LPA Ref: ^{FN/36/11/}
~~FP/193/11/~~

Proposal: Regeneration of Dilapidated Stableyard and Associated Buildings, comprising 1 No. Holiday Cottage, 2 No. New Dwellings (together with Replacement Dwelling, Ancillary Stables and Storage Barn as previously permitted under FN/437/09) to include Revised Vehicular access arrangements to provide separate access for Stables - amendment to Refusal FN/83/10 (this Application is a Departure from the Development Plan and lies within the South Downs National Park Authority)

Address: Soldiers Field, Soldiers Field Lane, Findon.

Scale	As Indicated @ A1	Drawing Number
Date	August 2011	10/157/p06A
Drawn	GM	© GWP Architects Ltd (UK) - 2011

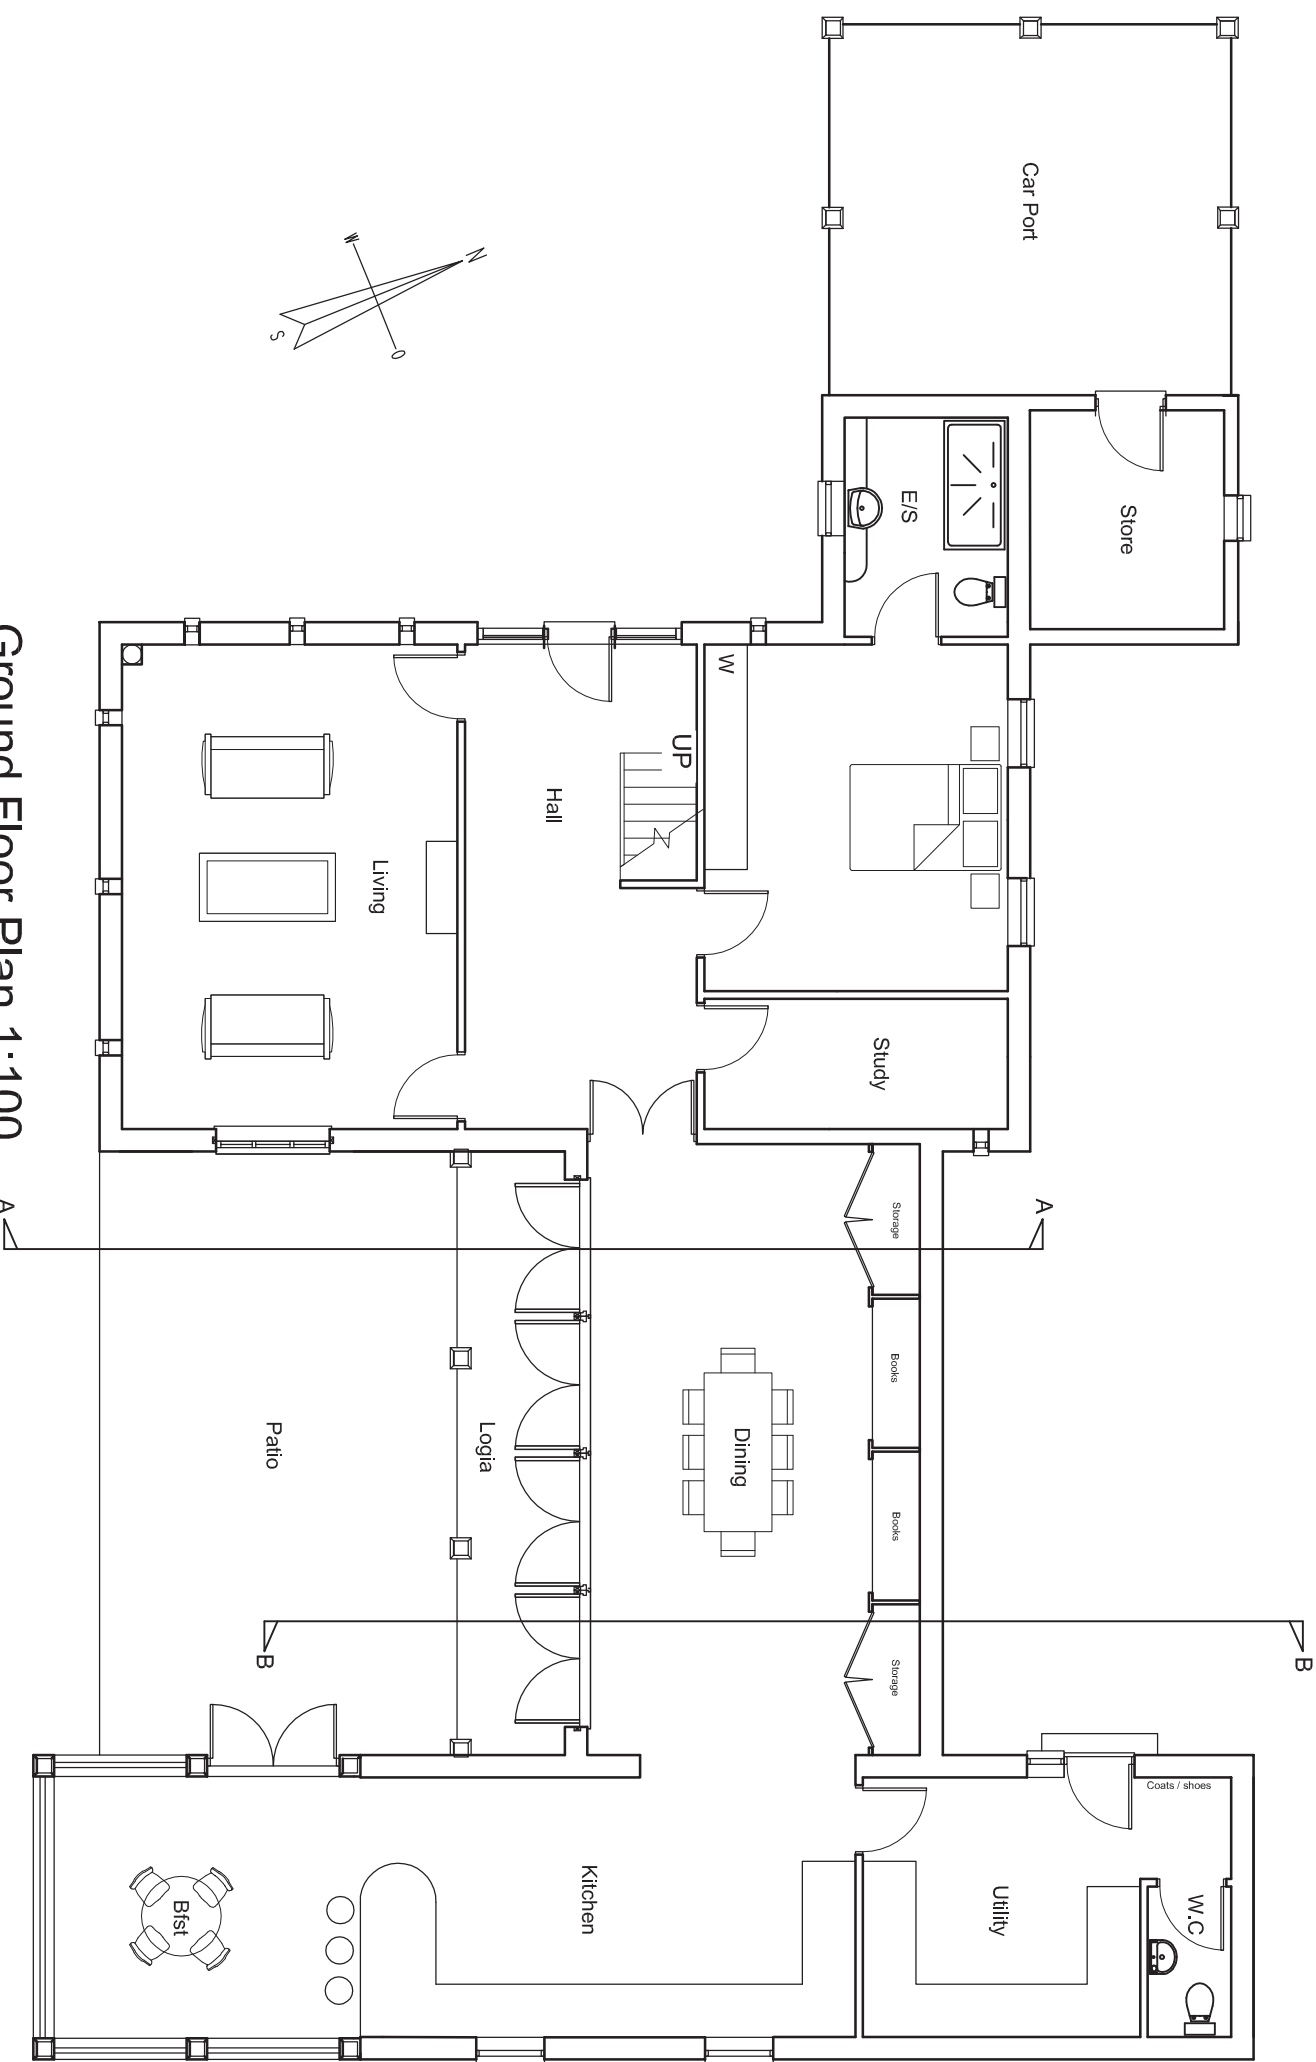
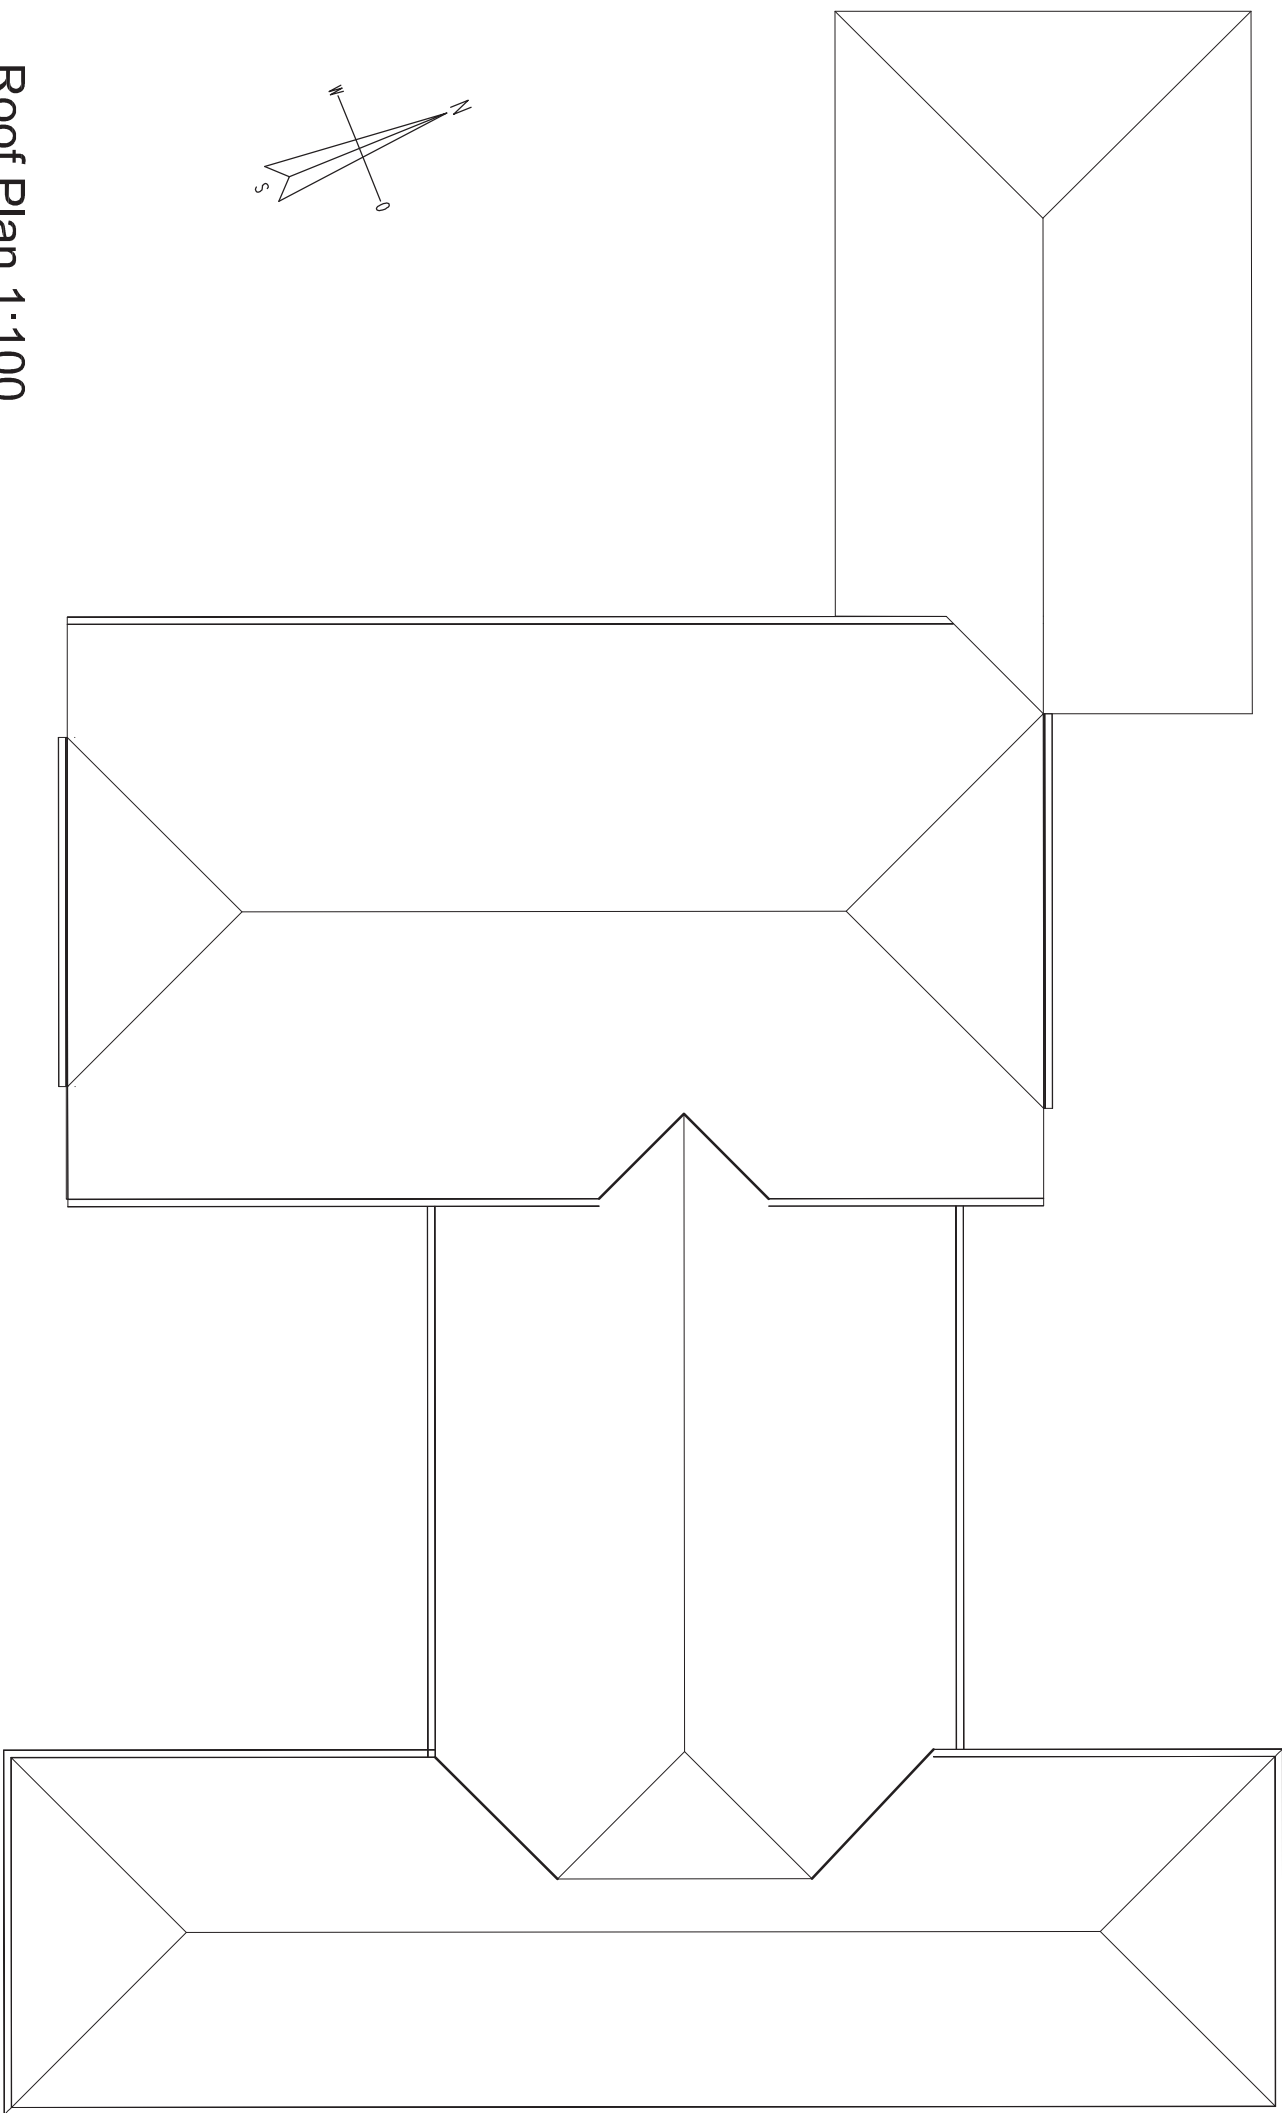
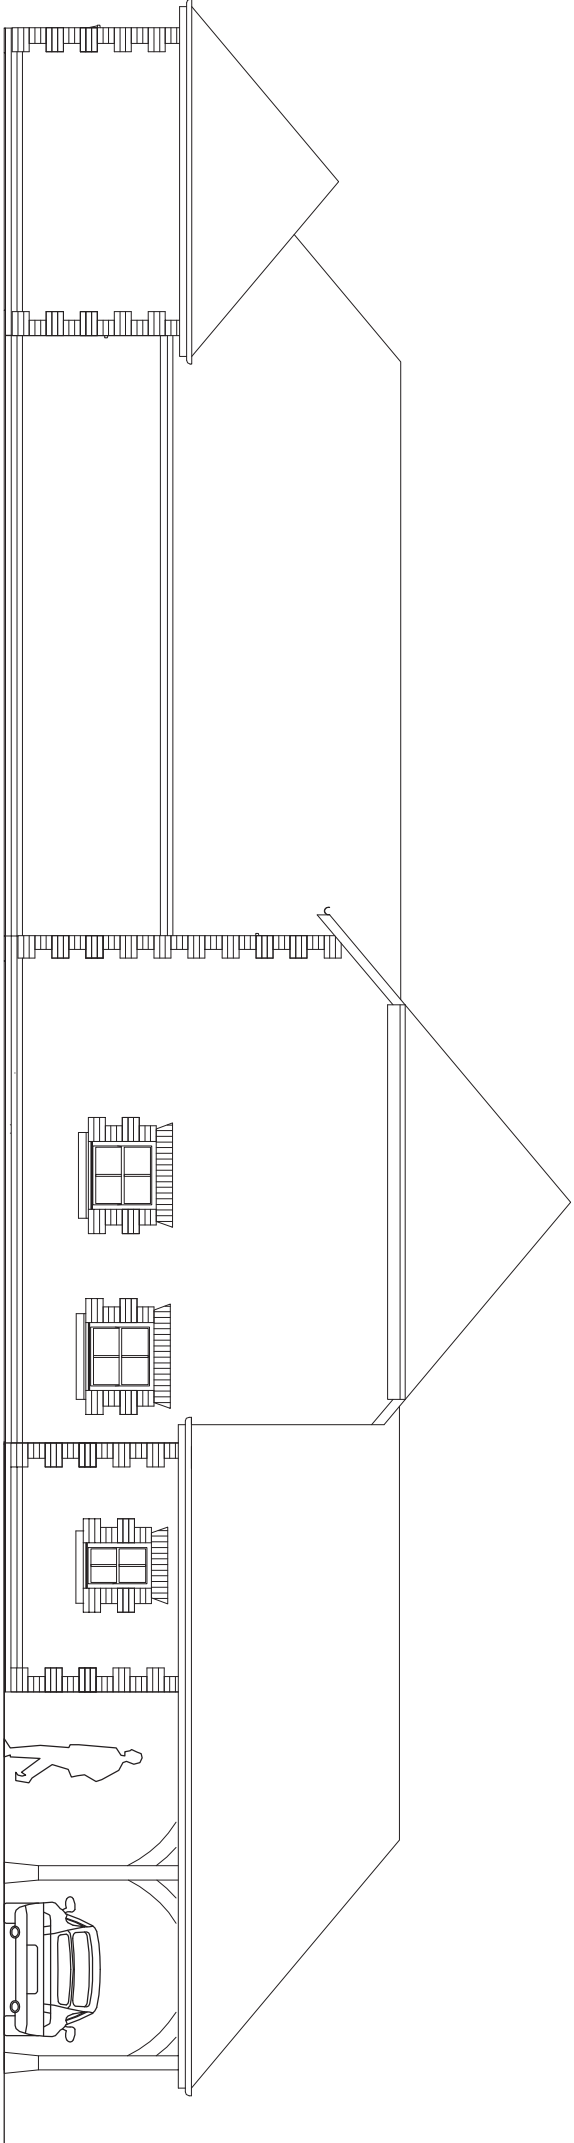
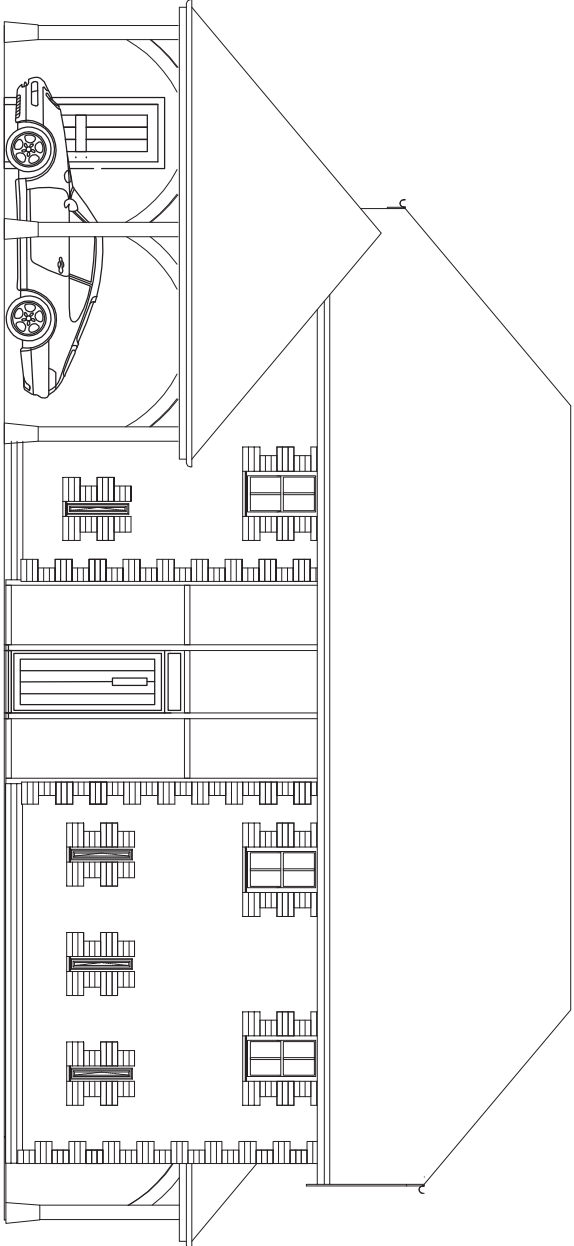
Please provide 1 electronic or 3 paper copies of a revised proposed plan (The Barn - drawing no. 10/157/p06). There is a store window shown on the north elevation and a small window shown on the west elevation (to right of car port) which are not shown on the ground floor plan.
